A1 in Northumberland: Morpeth to Ellingham

Scheme Number: TR010059

Summary of Proposed Changes to Application

December 2020

Key

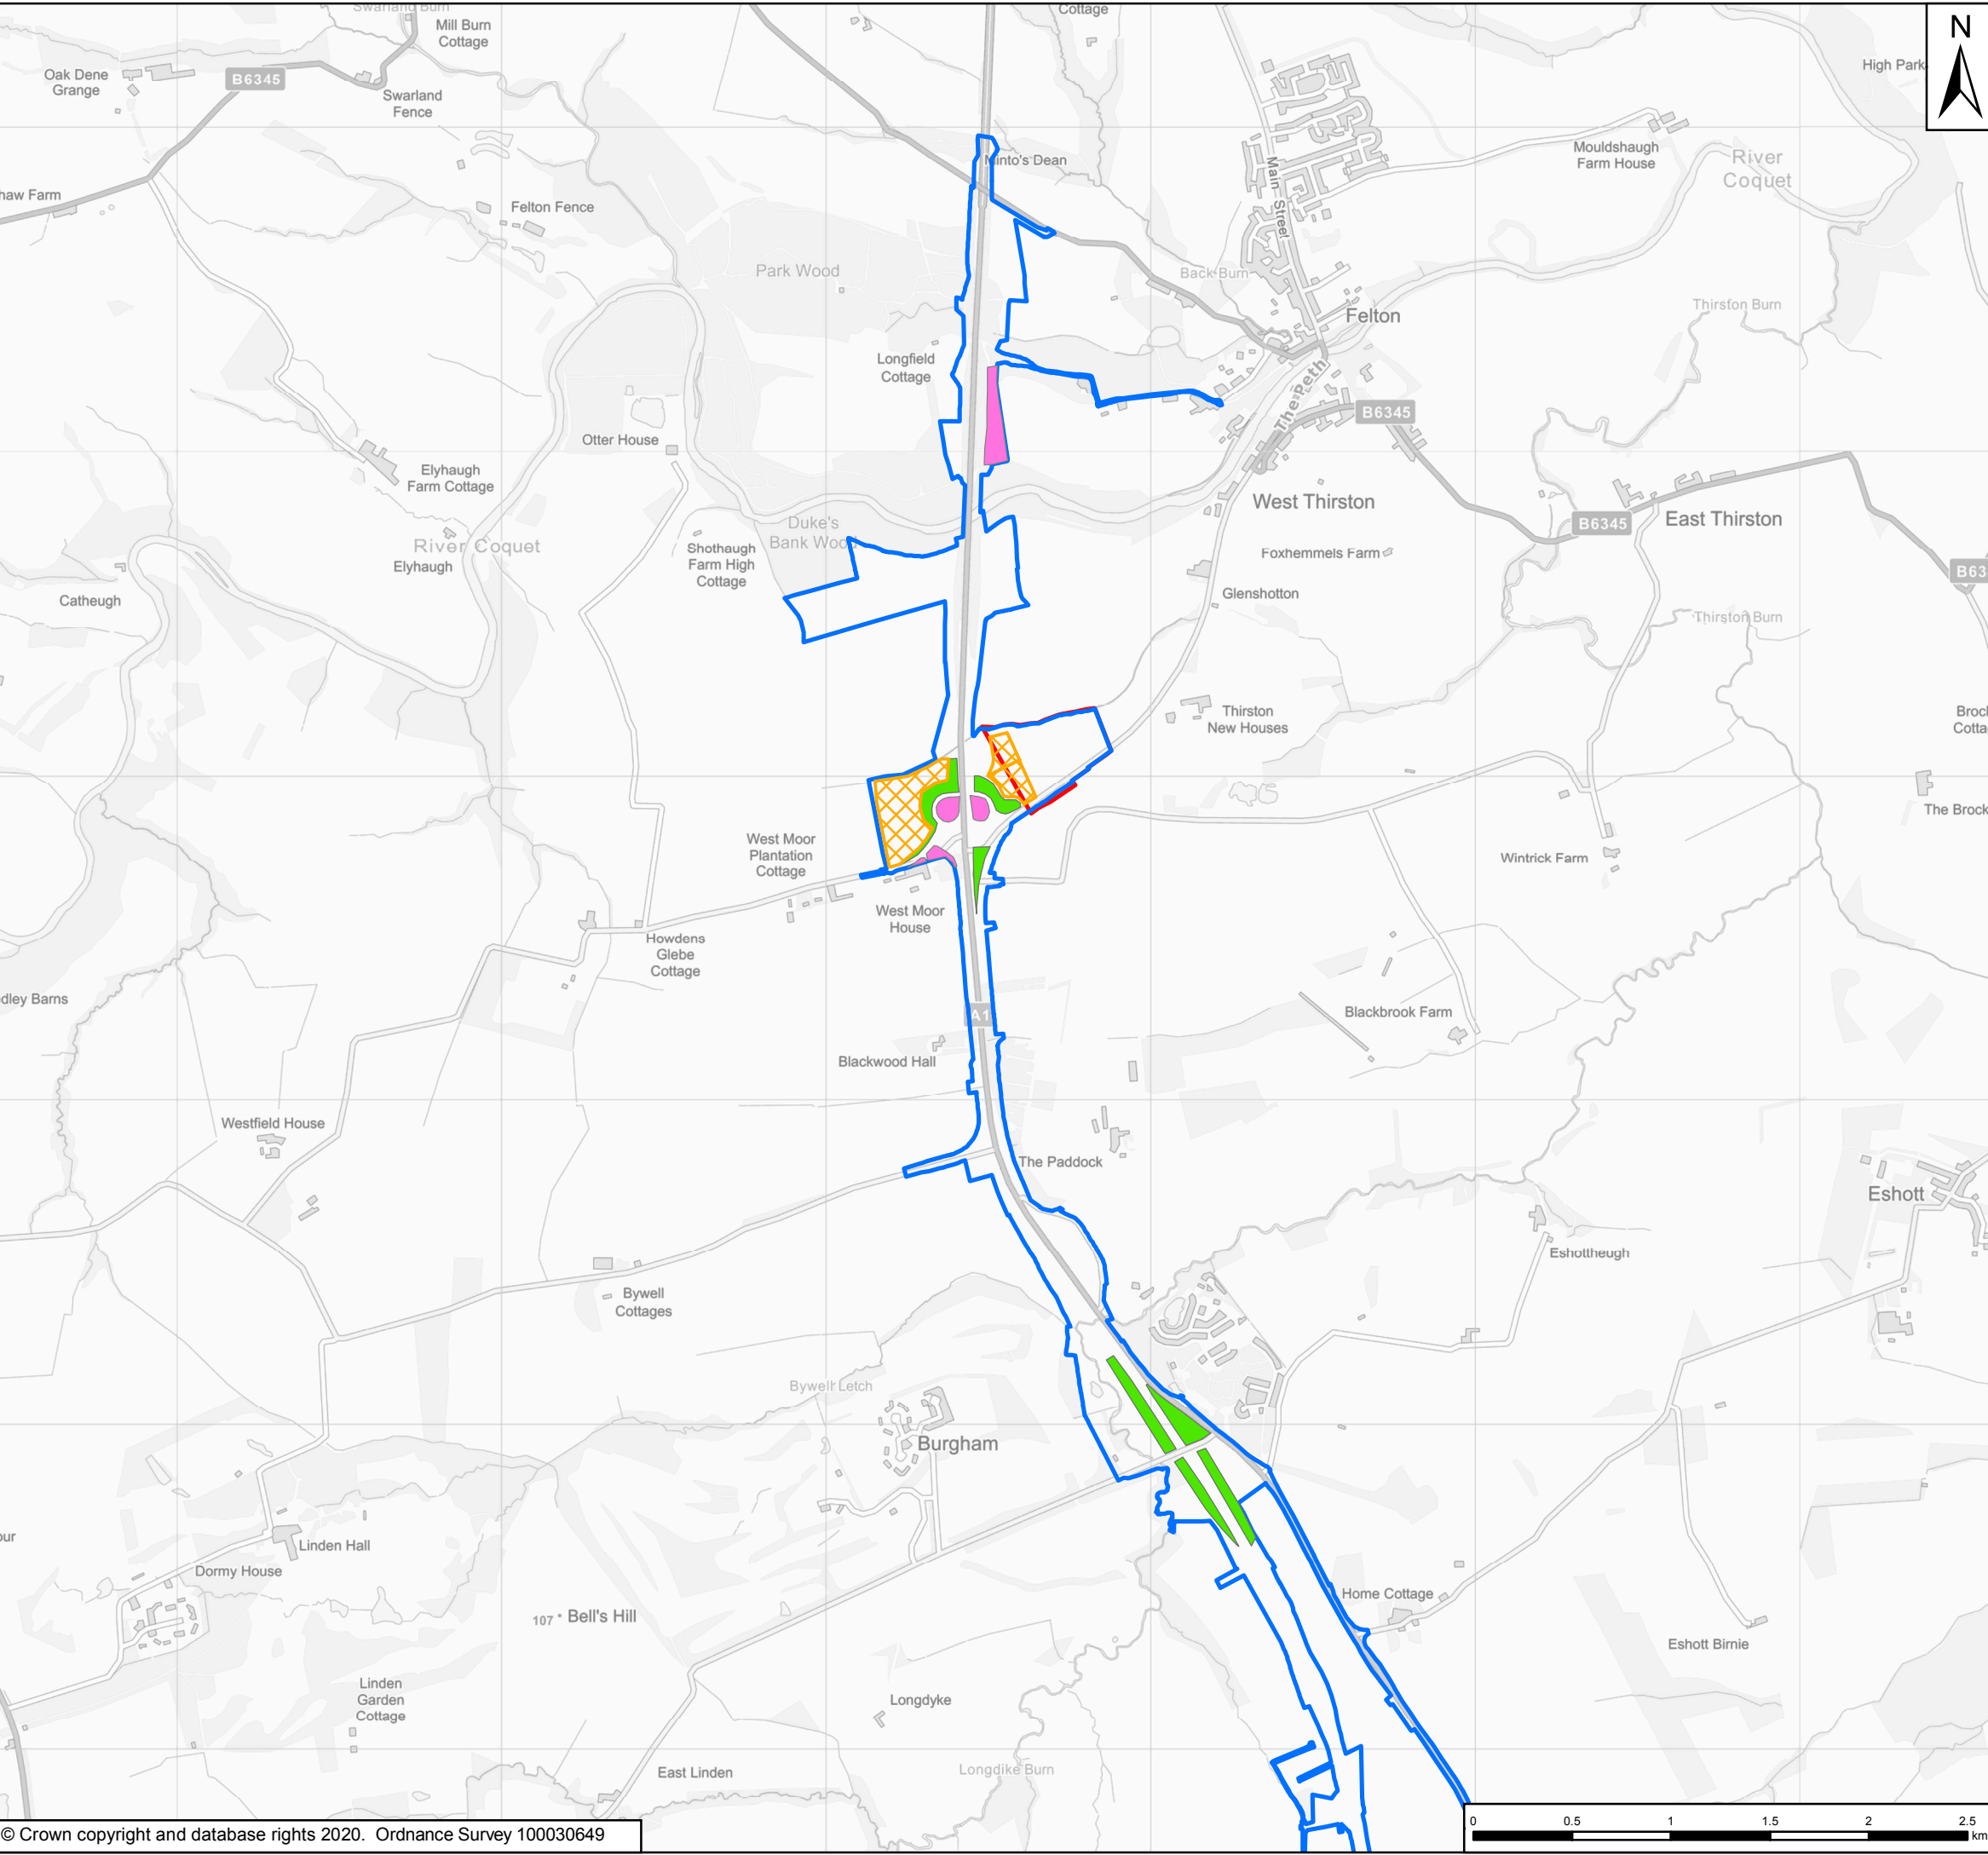
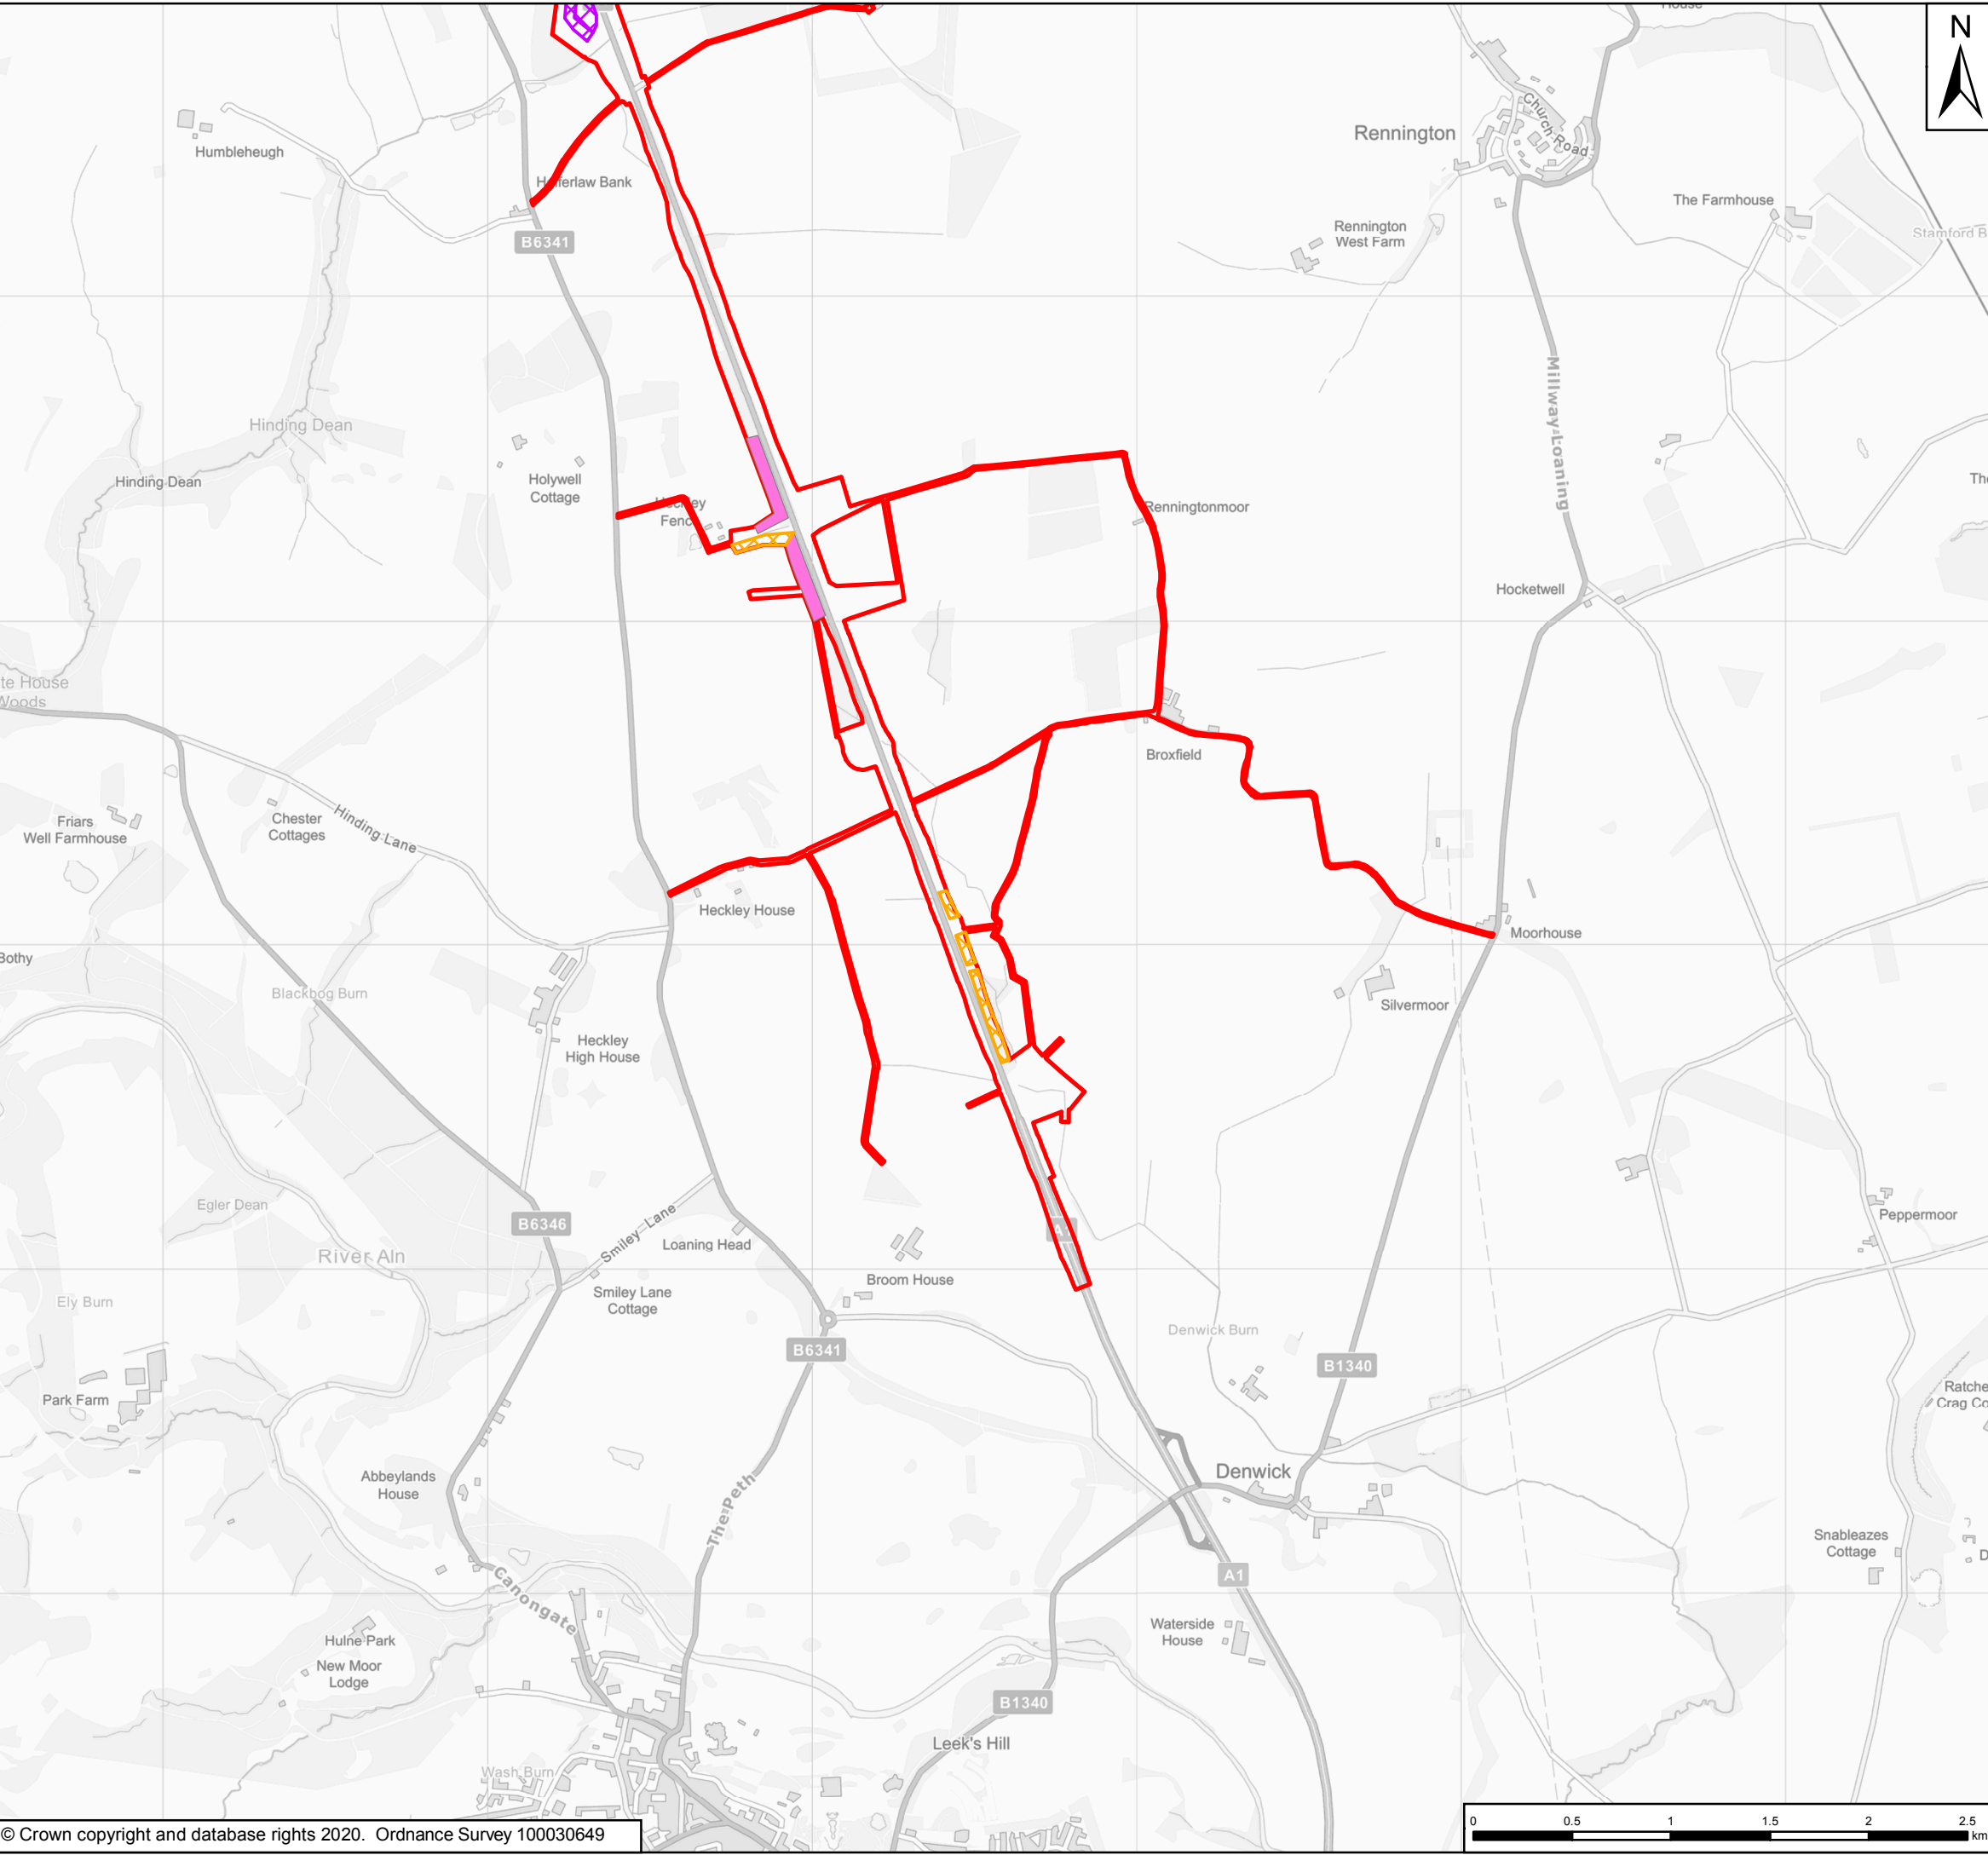
- 2.1.1 The Applicant proposes to maximise the re-use of materials (via excavation, deposition and temporary storage), within the existing Scheme extents. A recent review of the earthworks strategy has identified an opportunity to reduce earthwork movement and as a result greater flexibility in temporary and permanent storage of Site won material is required to achieve this. The indicative earthworks areas are shown in the figure in the **Indicative Earthwork Change Locations** figure in **Appendix A**.

- 2.1.2 To balance materials across both Parts A and B, the following methods are proposed:
- Utilising borrow pits to exchange and win additional material suitable for construction.

- Creation of new soil bunds within Part B to maximise re-use of excess site material.
 - Maximising of slopes for re-use of excess site material, in Part B.

- Laying down additional material increasing some localised ground levels.
 - Raising levels of junction “bowls” (level or rounded rather than dished).

- Creating new, temporary soil storage areas within both Part A and Part B.
- 2.1.3 These changes are an alteration to Parameters 4 and 5 for Part A, as set out in **Chapter 2: The Scheme** of the ES [APP-037]. There would also be additional temporary and permanent earthworks that require assessment for Part A and Part B. Therefore, it is appropriate to ensure that the environmental information before the Examination addresses the prospect of altered impacts This is addressed by sensitivity testing as described at **paragraph 2.1.6** below.
